Subject: AW/198/18/PL 10 Wychwood Close, Craigweil. Reduction in parking space.

I am a director of Craigweil Private Estate Ltd. The company owns the estate roads and verges on behalf of the residents.

DRAWING TITLE
Site Plan, Block Plan and Location Plan

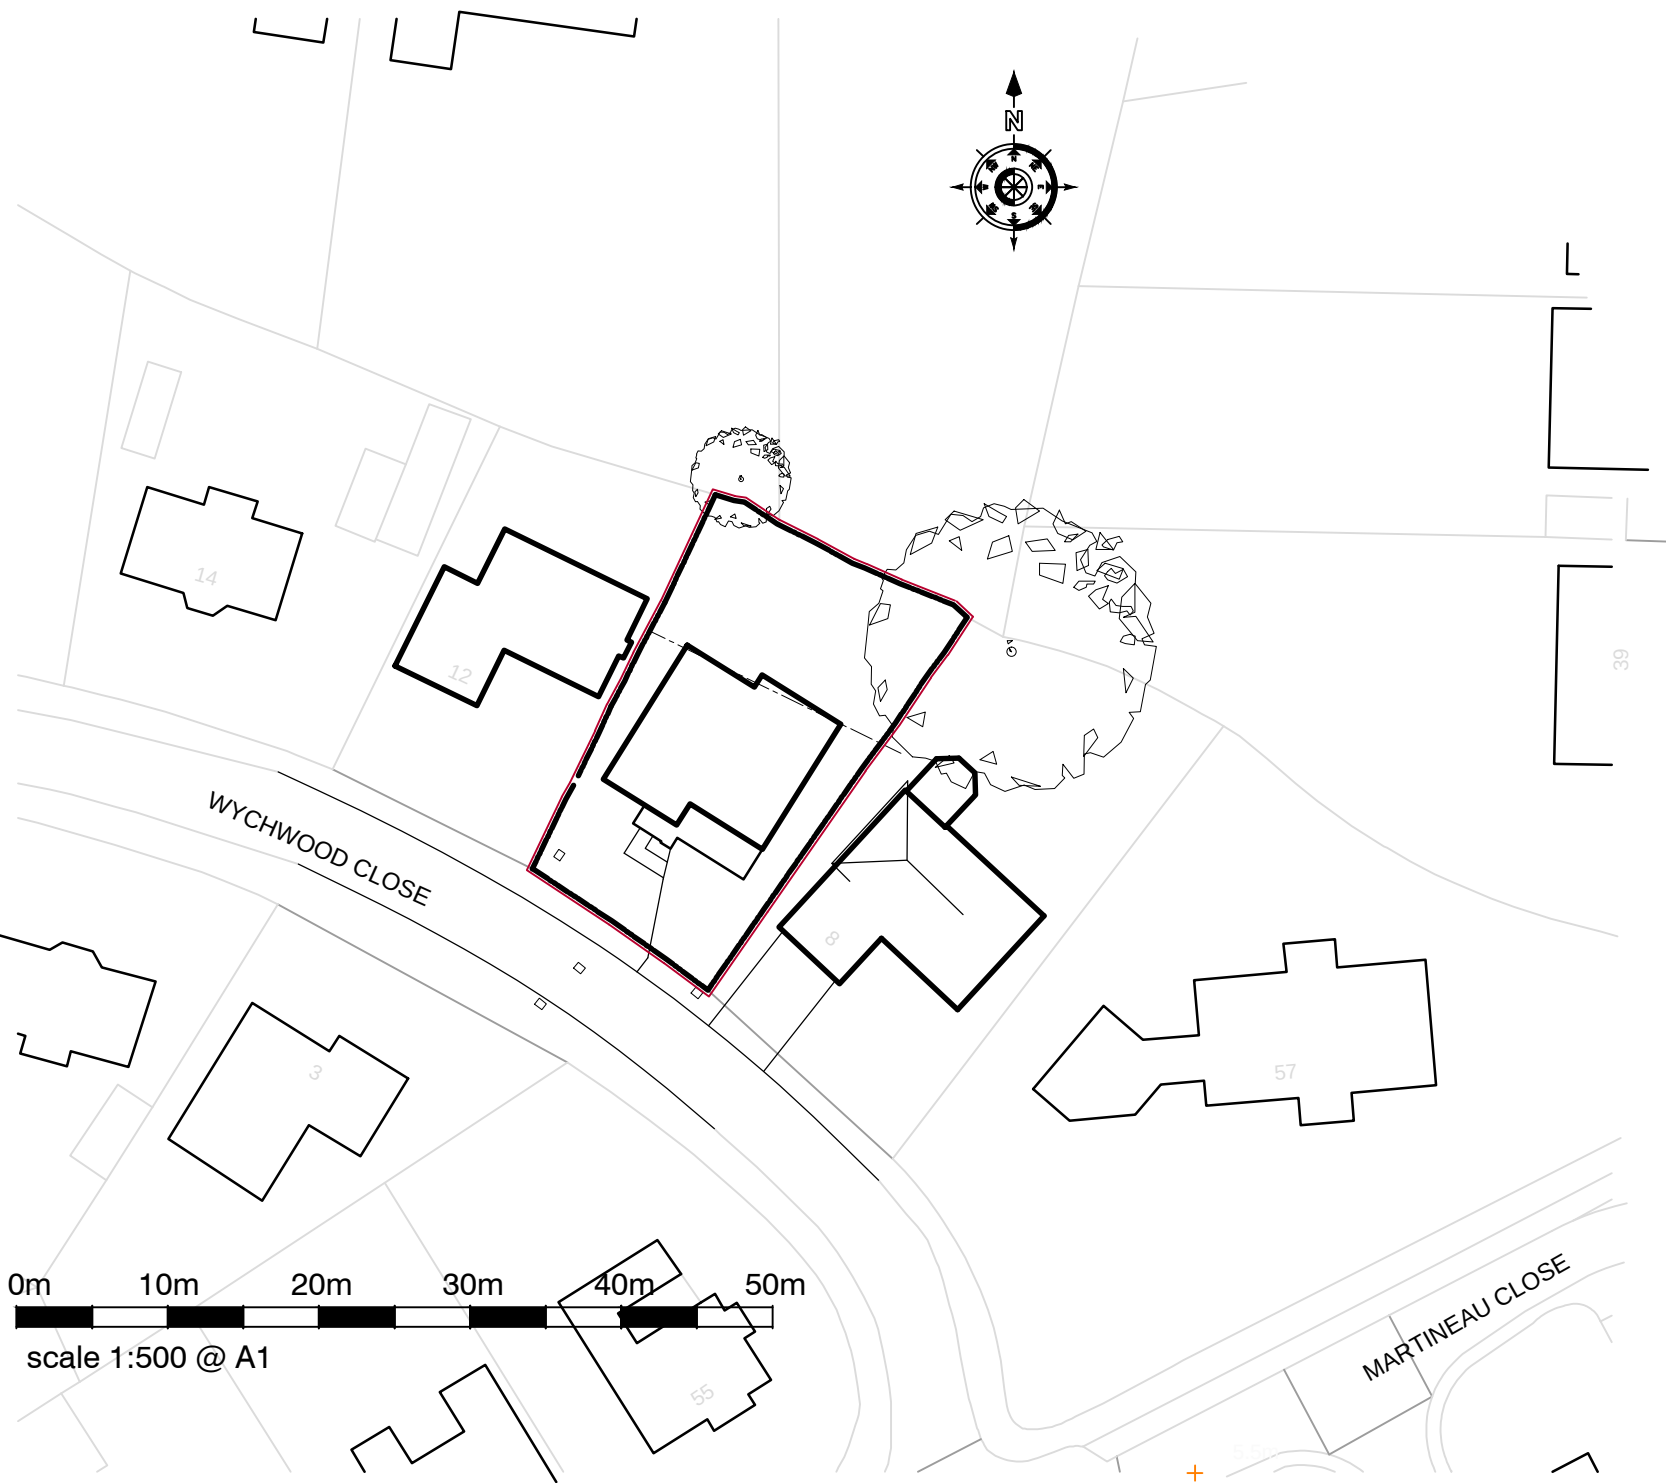
There is concern that the garage now contains an extra construction that would prevent the use of the garage for parking a vehicle. The planning consent shows parking for three cars, there being two cars on the drive, and a third inside the garage. Although this appears to be a double garage, part of the interior is taken up with a utility room.

CPEL would ask that the parking provision for three vehicles on the property as specified in the planning consent, is not eroded.

Ground Floor

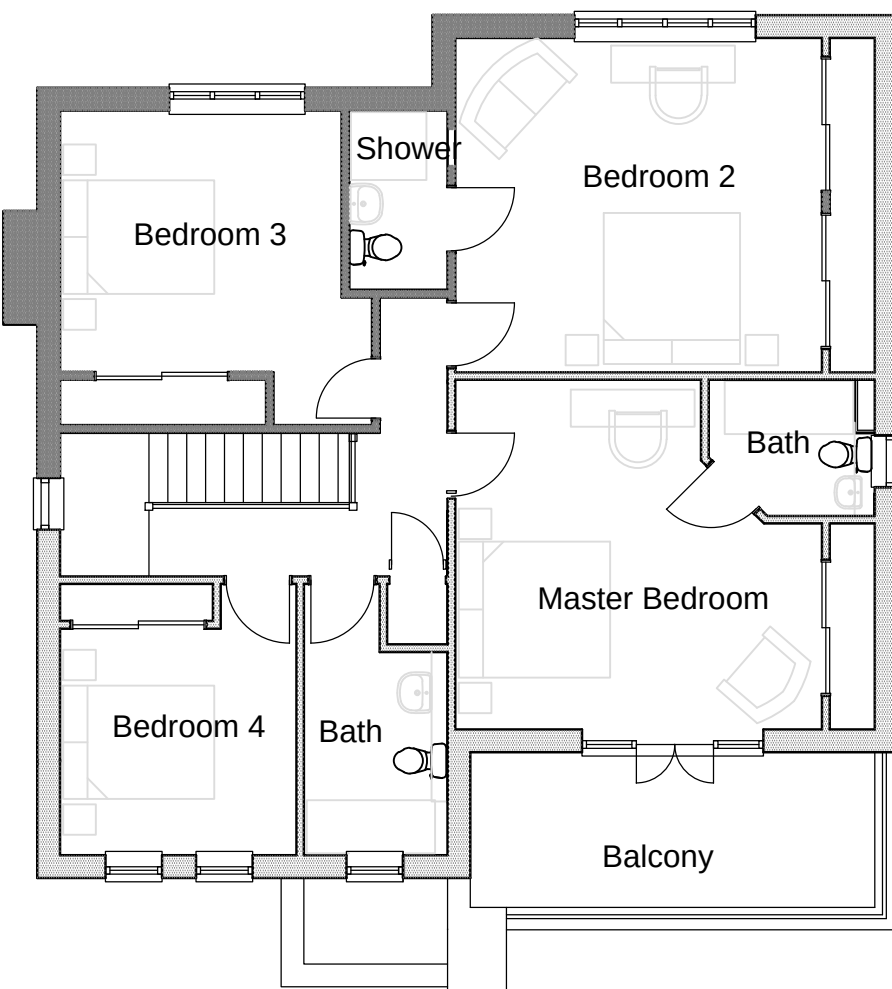
On Tuesday the 17th December I visited the site and spoke with Mr Gary Cotton, contracts manager for the developer. The area of the garage shown as a parking space now has a small plant-room installed against the back left corner. This would appear to prevent all but the smallest sized car from parking within the garage. We measured the length of parking space now available and found it to be 4mtrs. Mr Cotton mentioned that it would be possible to provide parking for three vehicles on the drive by making minor adjustments.
